RE: Submission to proposed application for 10, 14 & 14a Stanhope Road, Killara  
(SSD-81890707)

Regarding the application for the proposed development of 135 residential units to 10, 14 & 14a Stanhope Road, Killara, I object to the proposal in its current form.

1 Section A
Scale 1:200

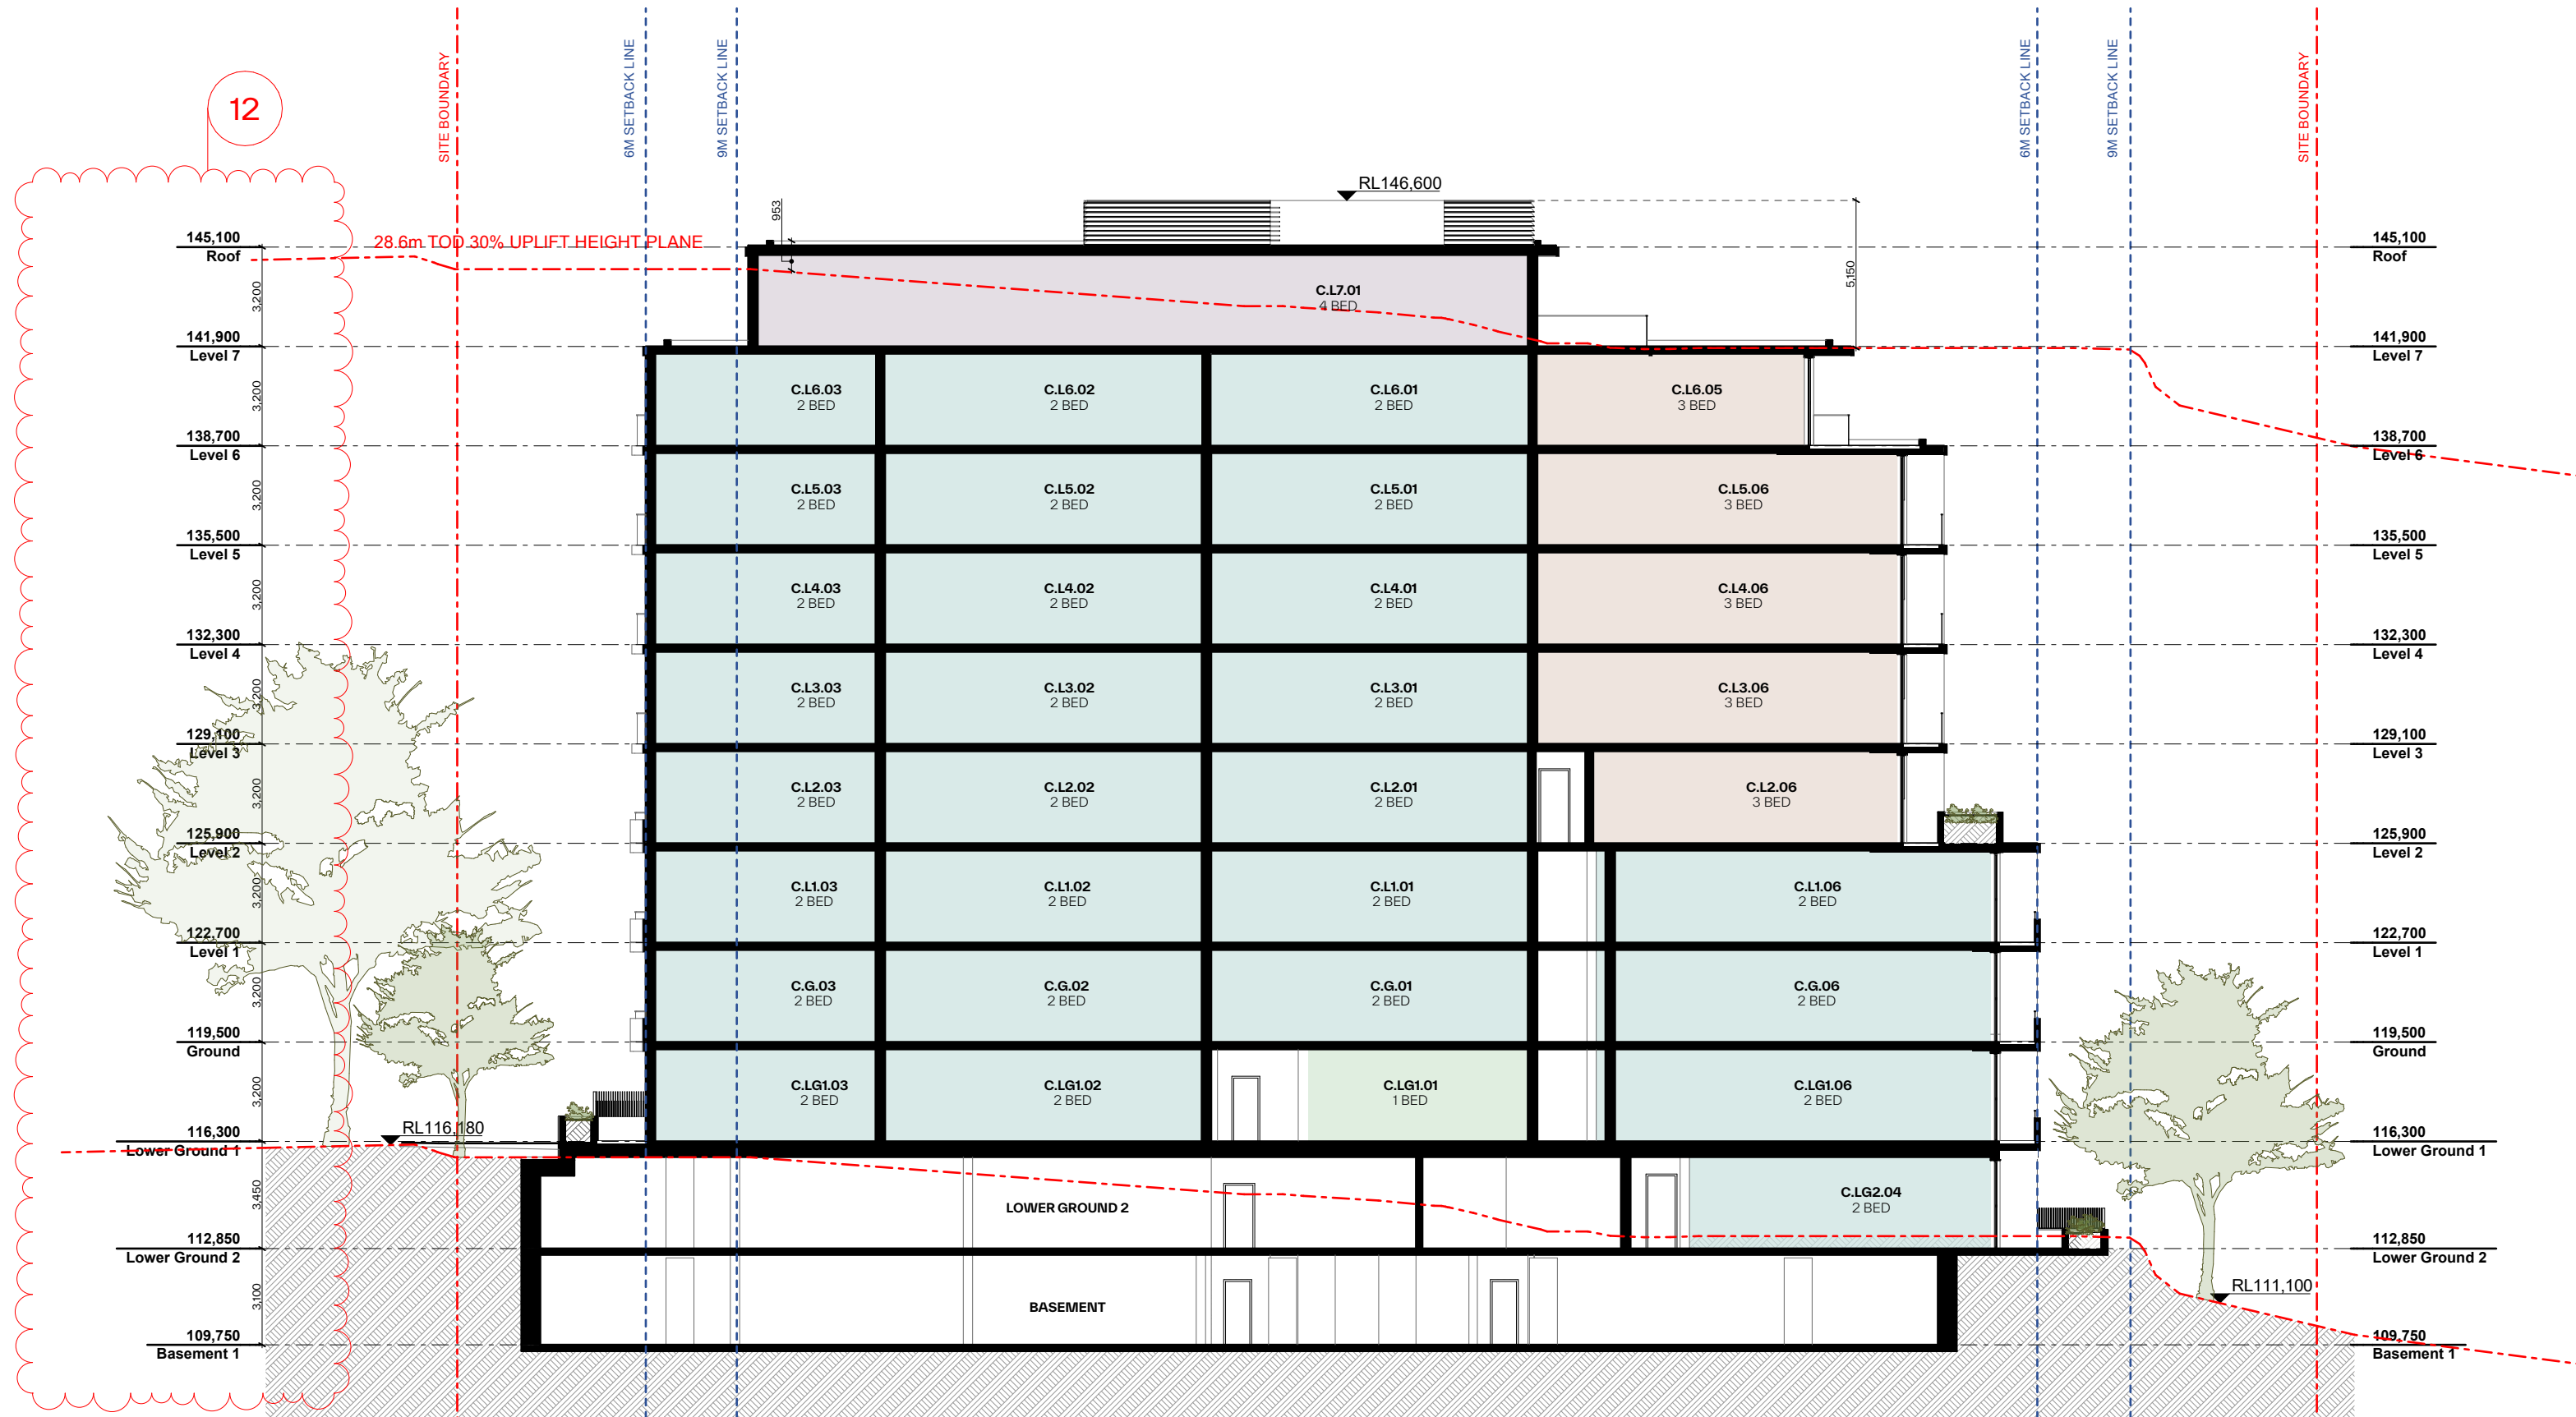
The proposed maximum height is 36m. This is a 25.8% variation to the maximum bonus height, or a 63.6% variation to the maximum height without the bonus. This is a gross non-compliance with the relevant legislative requirements and is not justified in the Clause 4.6 variation request.

It should be noted that while the Clause 4.6 variation request notes the maximum proposed building height as 35m, the architectural plans (drawing DA300 - Section Sheet 1) measure 36m from existing ground level to top of building (RL149,300). The applicant's own Pre-DA submission notes the proposed maximum height as 36m.

I request that the maximum height plane of 28.6m be enforced as is intended by the legislated controls established in the Housing SEPP, which would include deletion of the top two floors of Building 2 and 3.
